**Consultation Response from KC,
 Lead Local Flood Authority**
2021/93674 Greenhead College, Greenhead Road, Huddersfield, HD1 4ES
Partial redevelopment of Greenhead college including demolition and making good, erection of 2 and 4 storey buildings, reconfiguration of parking and access arrangements, reconfiguration of sports provision and other associated external works (Within a Conservation Area)
**Date Responded:
 27/10/2021**
**Responding Officer:
 Martin Stephenson**
**Responding Ref:
 0**

Drainage comments

However, the MicroDrainage Calculations and drainage drawing ref: NE8659-CCS-ZZ-XX-DR-D-0501 are not acceptable due to the following:

Drawing No.
NE8659-CCS-ZZ-XX-DR-D-0501

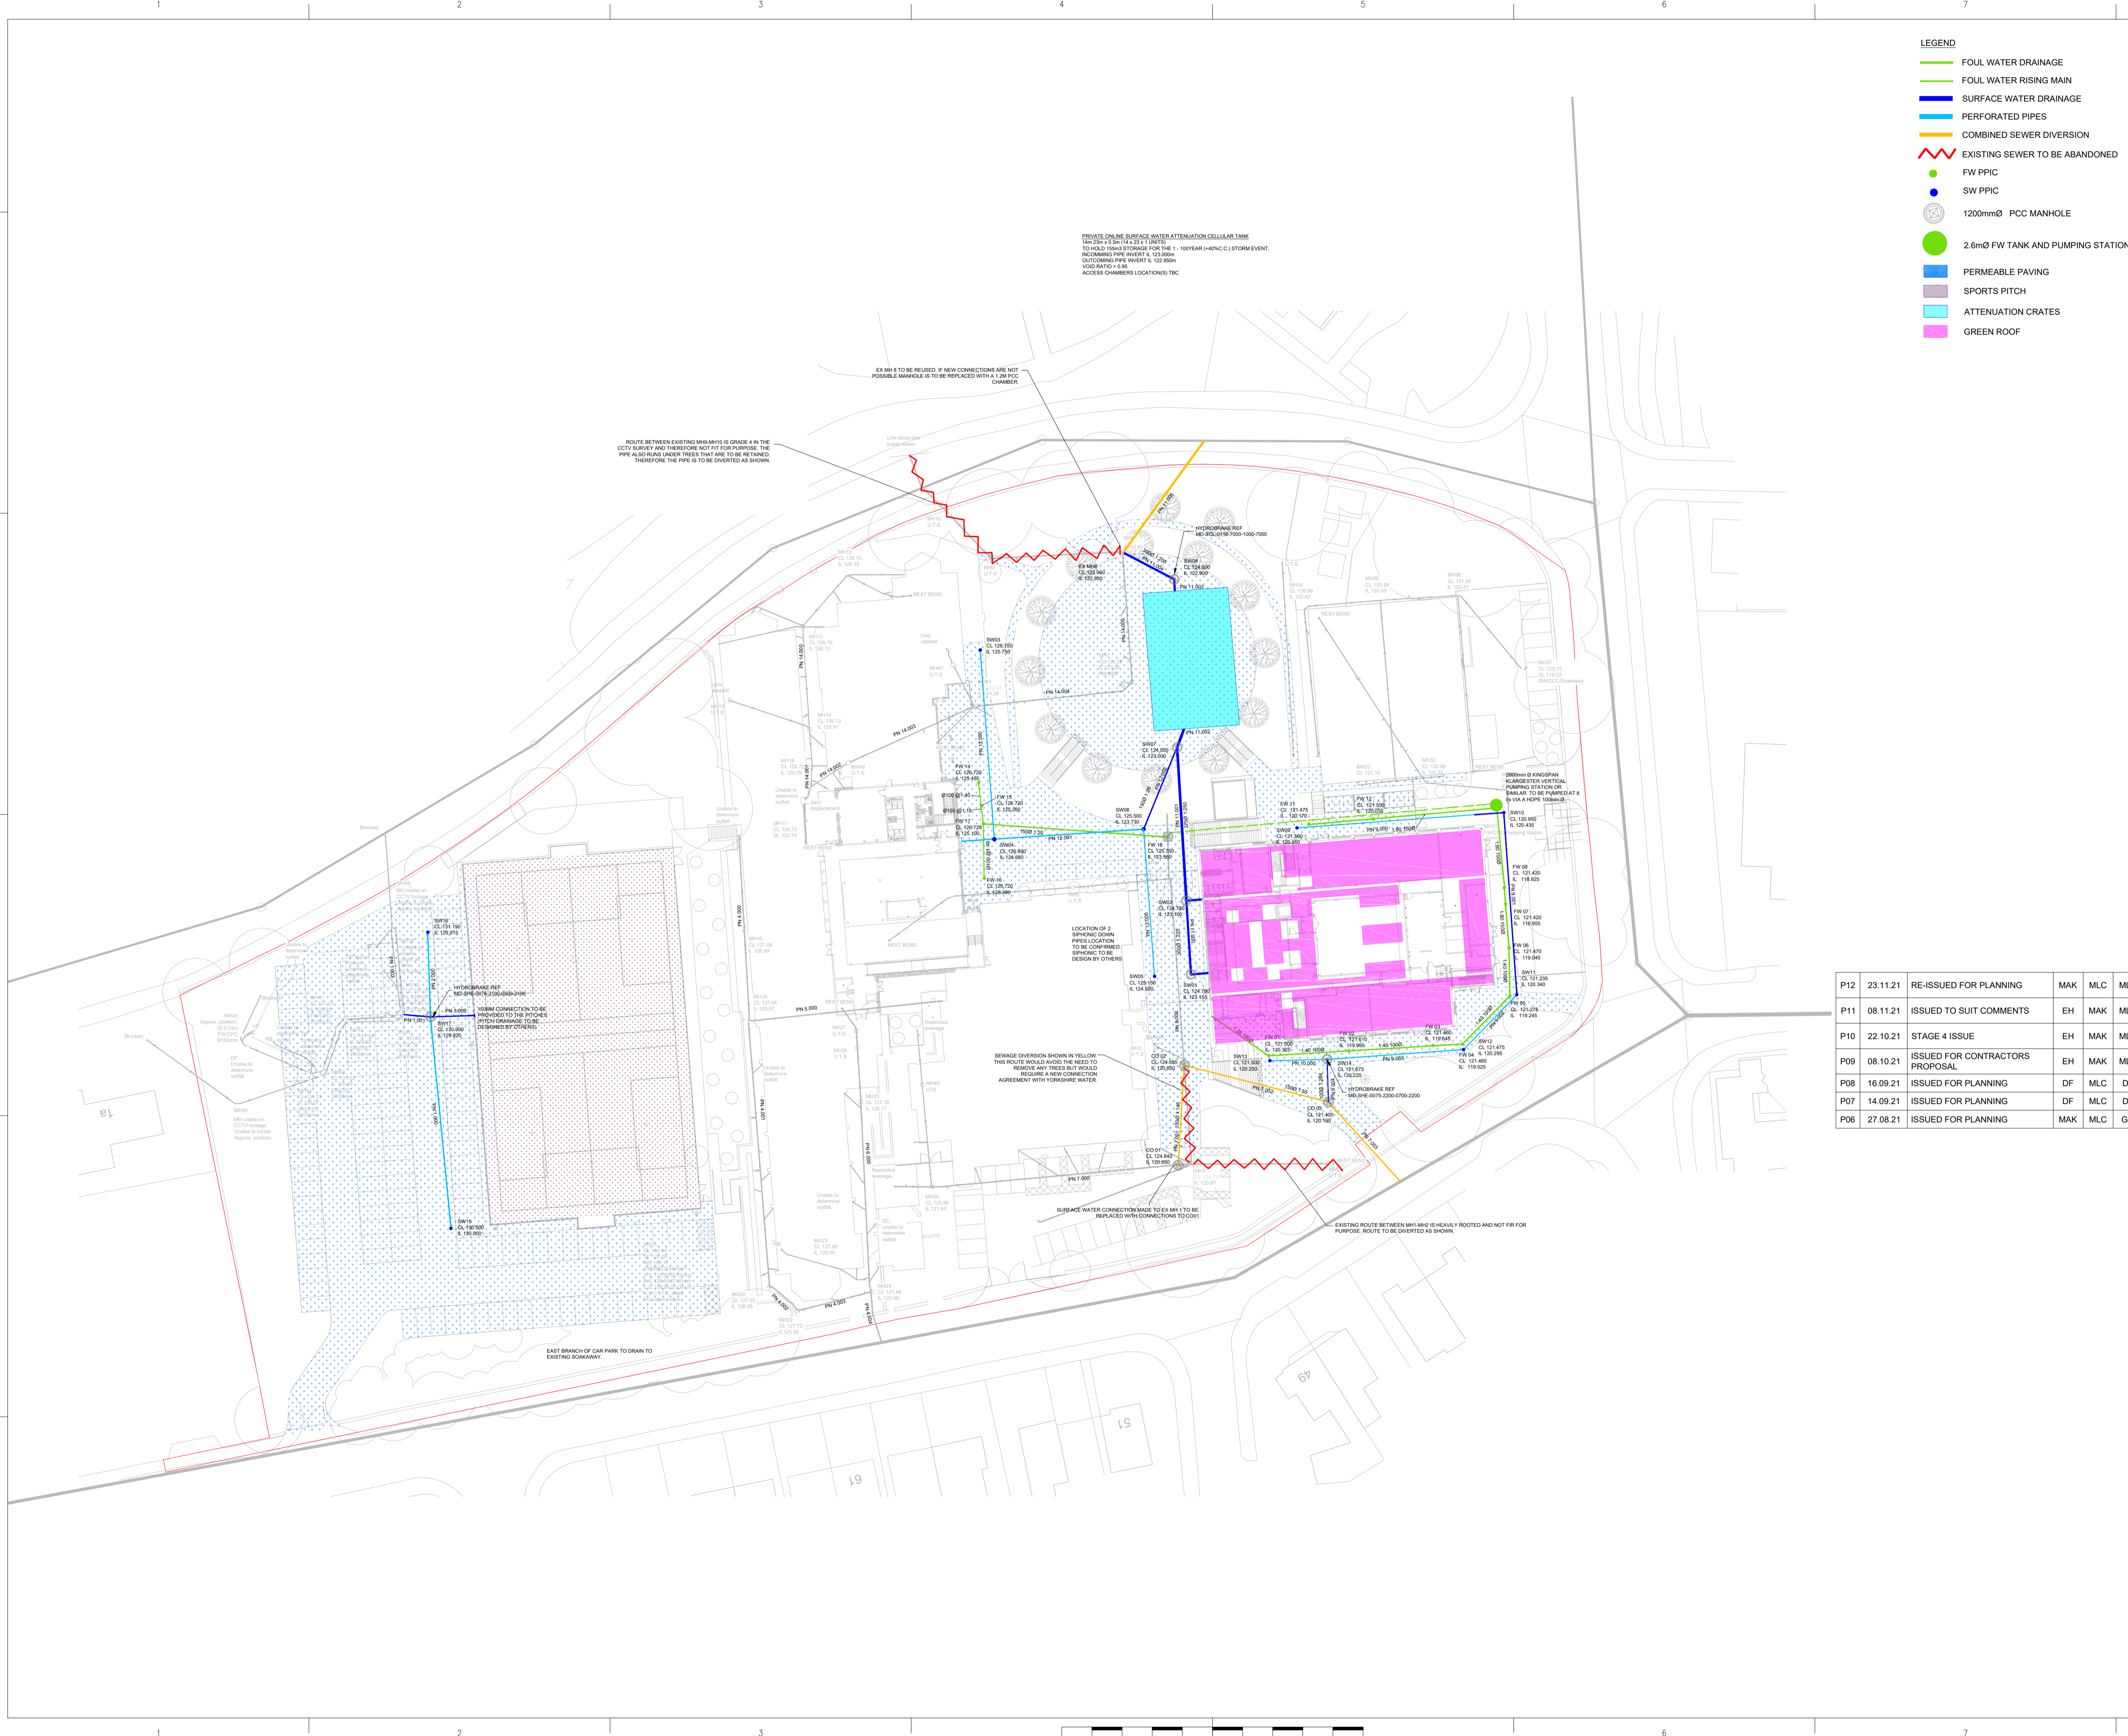
1. The simulated maximum water levels in the MHs for the critical 1 in 100 year storm (plus 30% CC) are not provided in the calculations.
2. The volume of flooding (if any) produced by the critical storm is not shown in the calculations.

3. The rating and size of the hydrobrake on the outlet from the storage tank (SW08) is not indicated.
4. The PN numbers in the calculations are not indicated on the drainage plan making cross-referencing very difficult.

5. The calculations indicate several hydrobrakes with outlet diameters less than the acceptable diameter of 75 mm – these small diameter outlets will be prone to blockage and should be avoided.

6. The outlet from MH SW 14 connects to the YW sewer in Greenhead Road without any apparent attenuation. (Note that the flow through this MH can discharge at an unattenuated rate provided a compensatory reduction is made to the main outlet to the sewer in Park Drive South).

Kirklees Flood Management and Drainage, as the Lead Local Flood Authority (LLFA), OBJECT to this planning application and require FURTHER INFORMATION is provided on the following:

Revised MicroDrainage calculations as noted above
 Additional information added to the drainage drawing as noted above
 Flood routing plan
